Date: 13th April 2010
To: Planning
Cc: -
From: Miriam Hill
Subject: S6/2010/0265/MA – St. Audrey’s Care Home, 15 Church Street, Hatfield
Extension to existing care home

I have reviewed the application documents and visited the site for the above application. I refer to drawing 759-002 (Proposed Plans) and the Tree Survey dated 14th January 2009 which includes a plan entitled Tree Work St Audrey’s Care Home, Hatfield.

DRAWING TITLE:
 PROPOSED PLANS

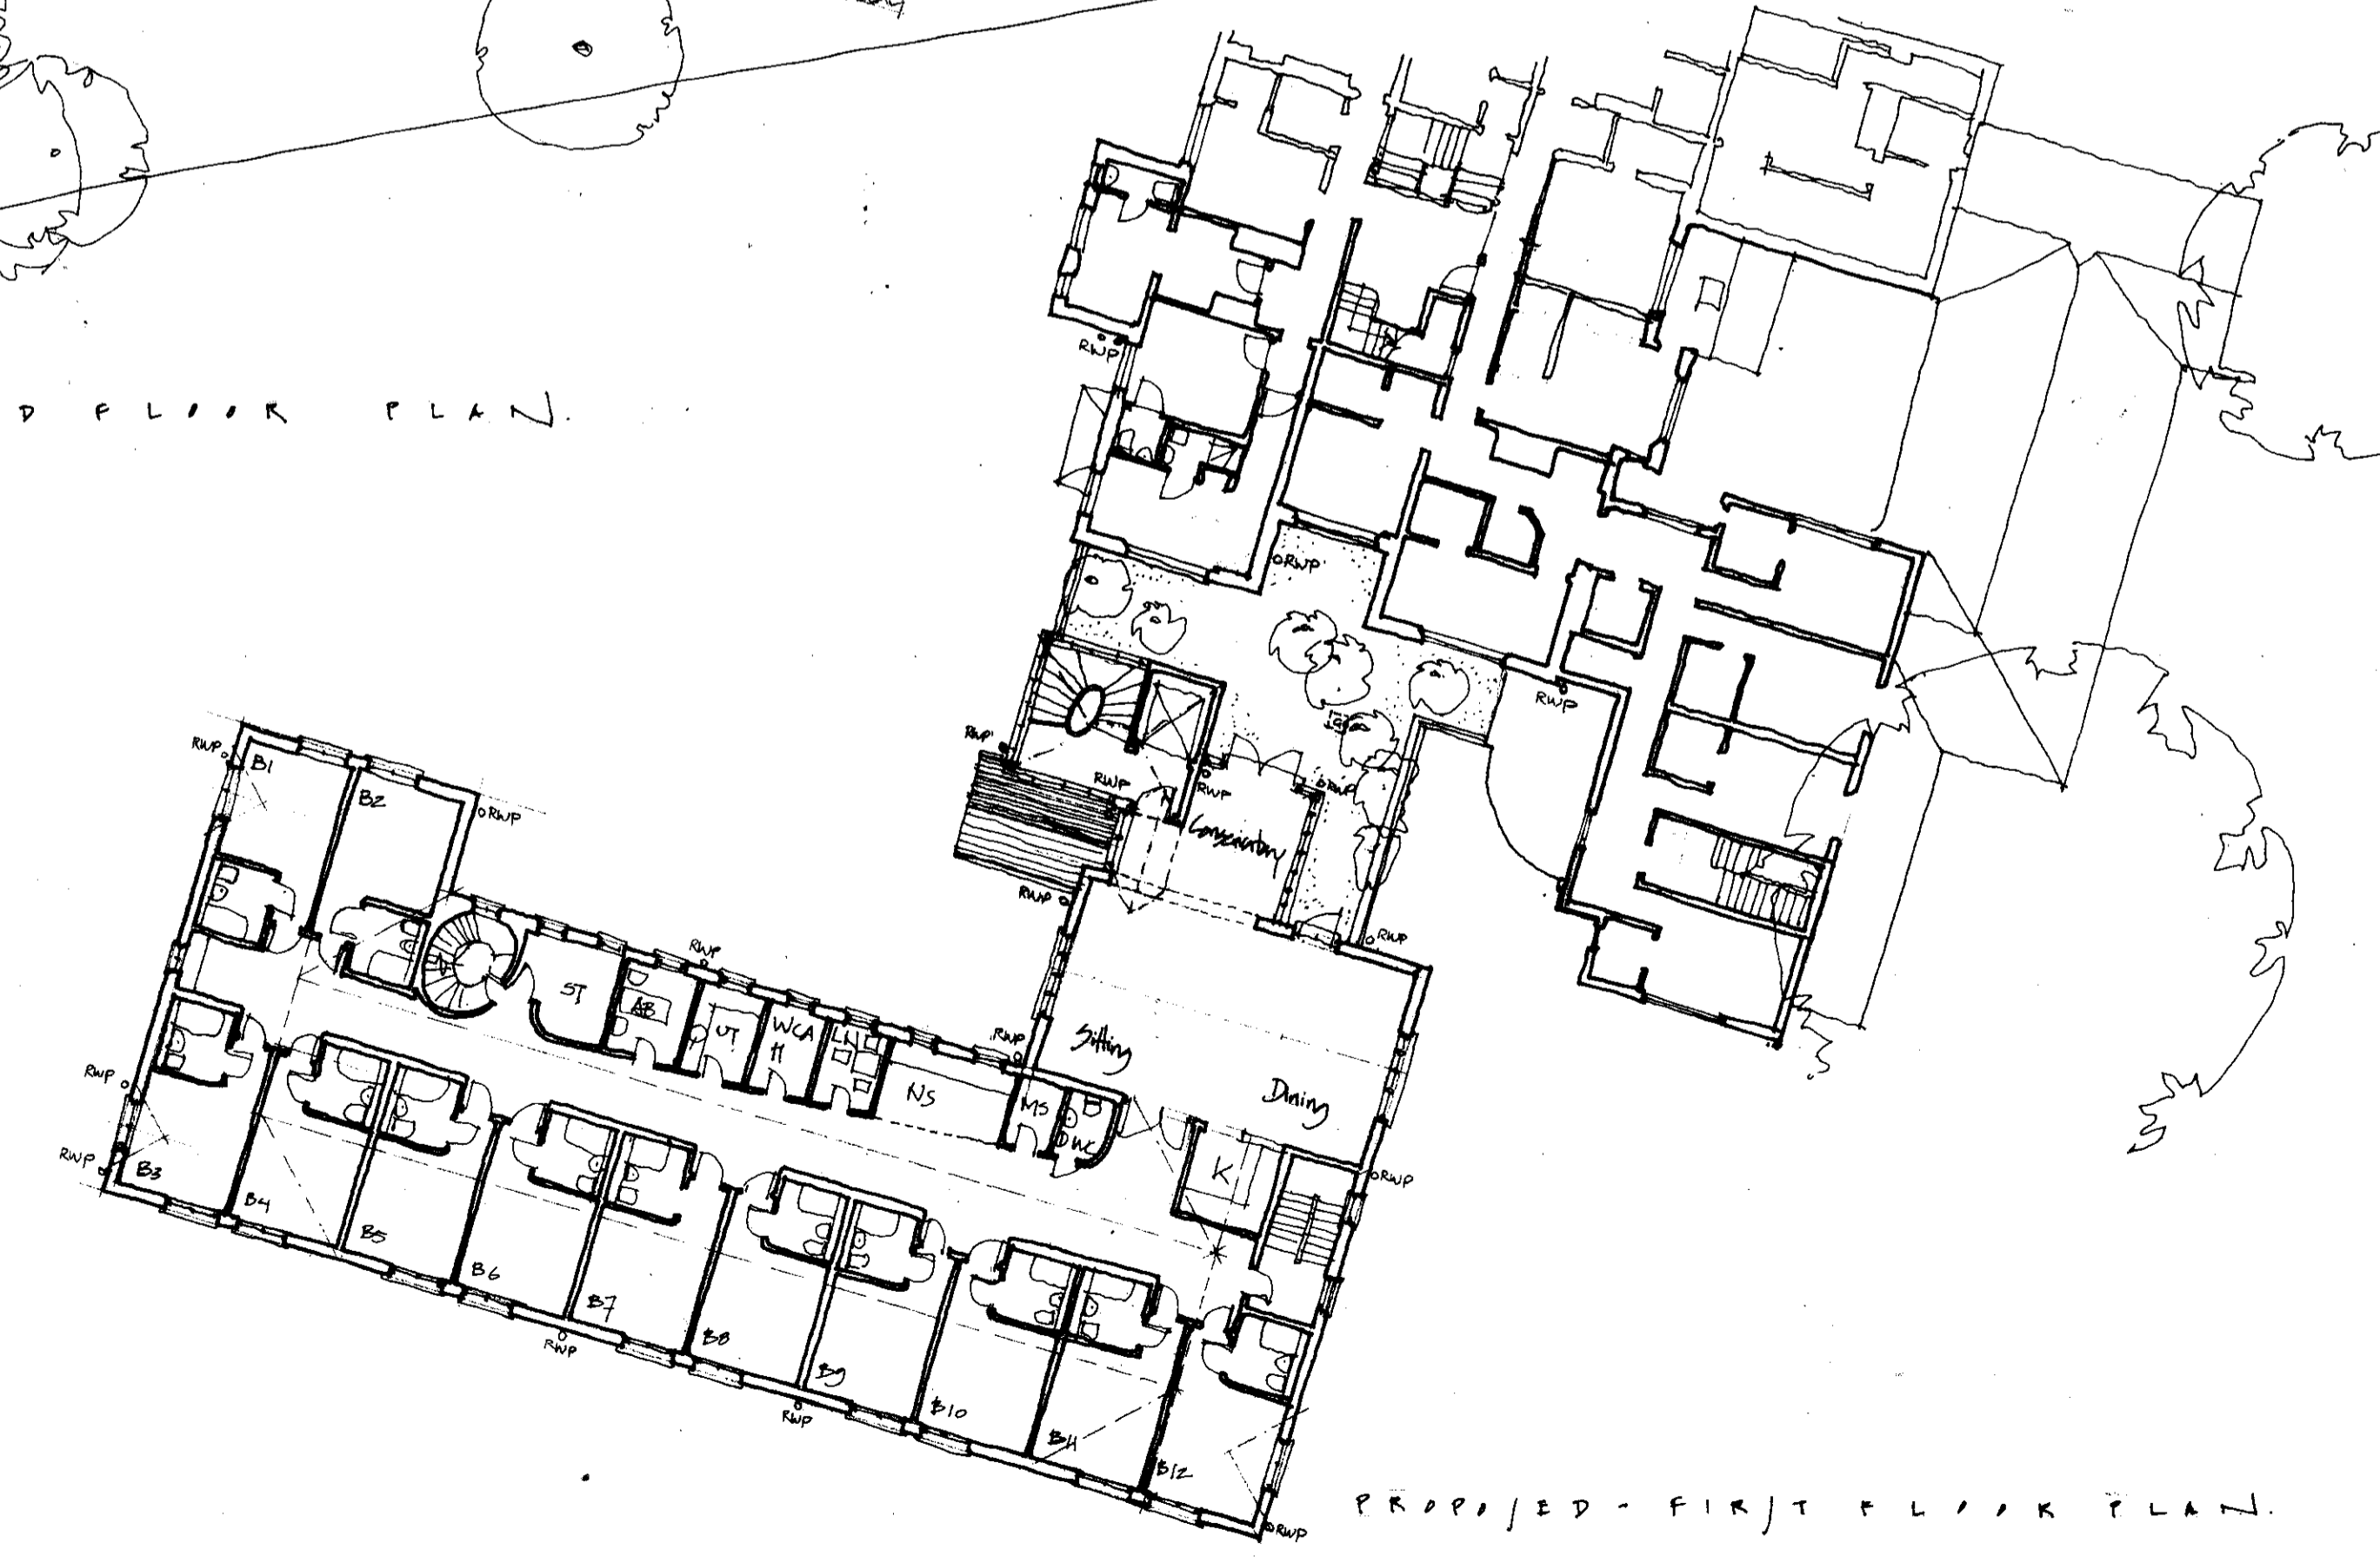
An area of trees which was not surveyed and will have to be removed for the proposal currently stands to the south-west of the building, near to the parking area. It contains a pine, sycamore and poplar. None of these trees has a high enough amenity value to warrant an individual TPO (Tree Preservation Order) and therefore it would be inappropriate to object to this application for these trees. However this group do add to the general amenity of the area and currently help to screen the residential home from the view down the hill to the A1000, Citroen garage and train line and the town houses, 12-19 Church Lane from Hatfield House’s coach access.

The loss of the trees adjacent to the road and within the grounds will have a large impact on this part of Old Hatfield. The care home will also have very little garden remaining. I could see no landscape plan included with the application documents. A careful design which includes ornamental areas around the home, heavy screening along both the road and the eastern boundary and diffuse screening along the southern boundary, will ease the appearance of the proposed site dramatically.

- A tree survey of all the trees on or adjacent to the site is undertaken. This should comply with BS5837:2005 Trees in Relation to Construction and be submitted for approval.
- A landscape plan, which includes details of species, numbers or density for planting and size of planting material should be submitted for approval.
- An Arboricultural Method Statement which complies with BS5837:2005 should be submitted for approval.
